Our Ref: R/199/25/NMA

**Section 96A of the Town & Country Planning Act 1990 (as amended)
Town and Country Planning (Development Management Procedure) (England) Order 2015
(as amended) - Article 10**

Non material amendment following the grant of R/73/25/HH to change colour of window to Anthracite Gray, change porch design including flat roof to front and side extensions, removal of new window to East and West elevations and reconfiguration of kitchen doors/window.
1 Hudson Drive Rustington BN16 2AX

PROPOSED AMENDED
ELEVATIONS BEING
SUBMITTED UNDER THIS
APPLICATION

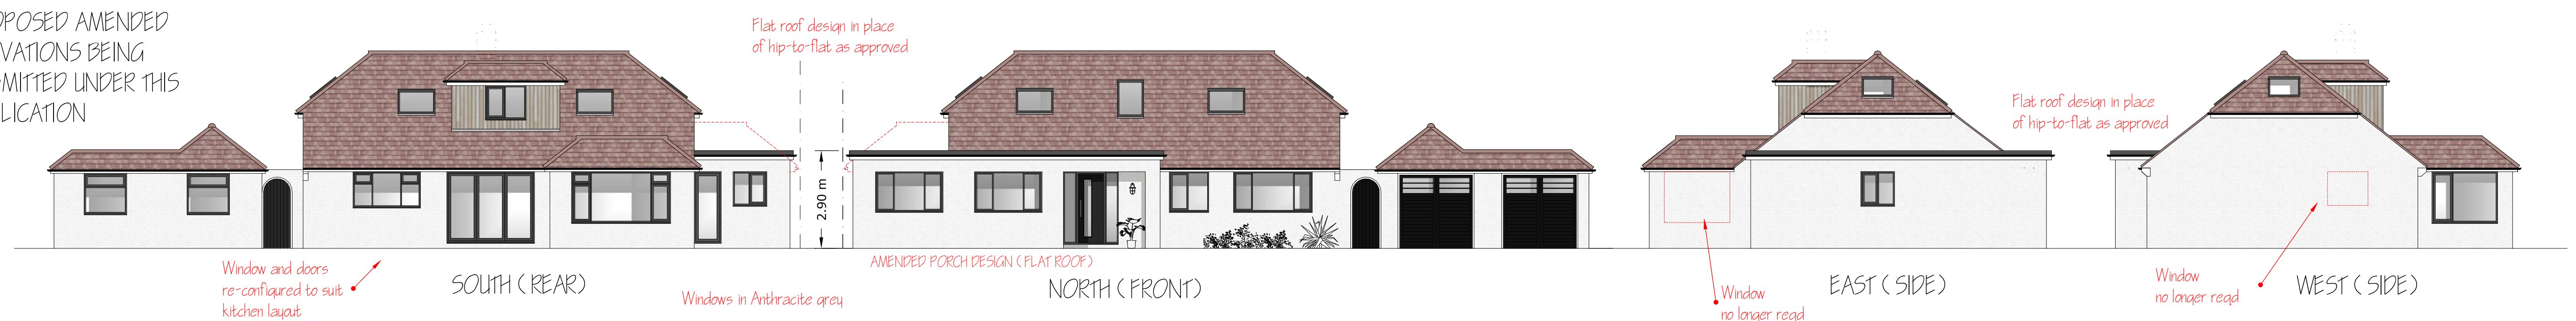
The reasons that these proposals have not been accepted as Non-Material Amendments is because the proposal introduces a large flat-roofed element to the front of the building. This represents a significant change to the external details which would materially alter the appearance of the dwelling. It cannot therefore be considered under section 96A of the Town and Country Planning Act 1990.

From the information submitted I am unable to take the alterations as a Minor Amendment to R/73/25/HH.
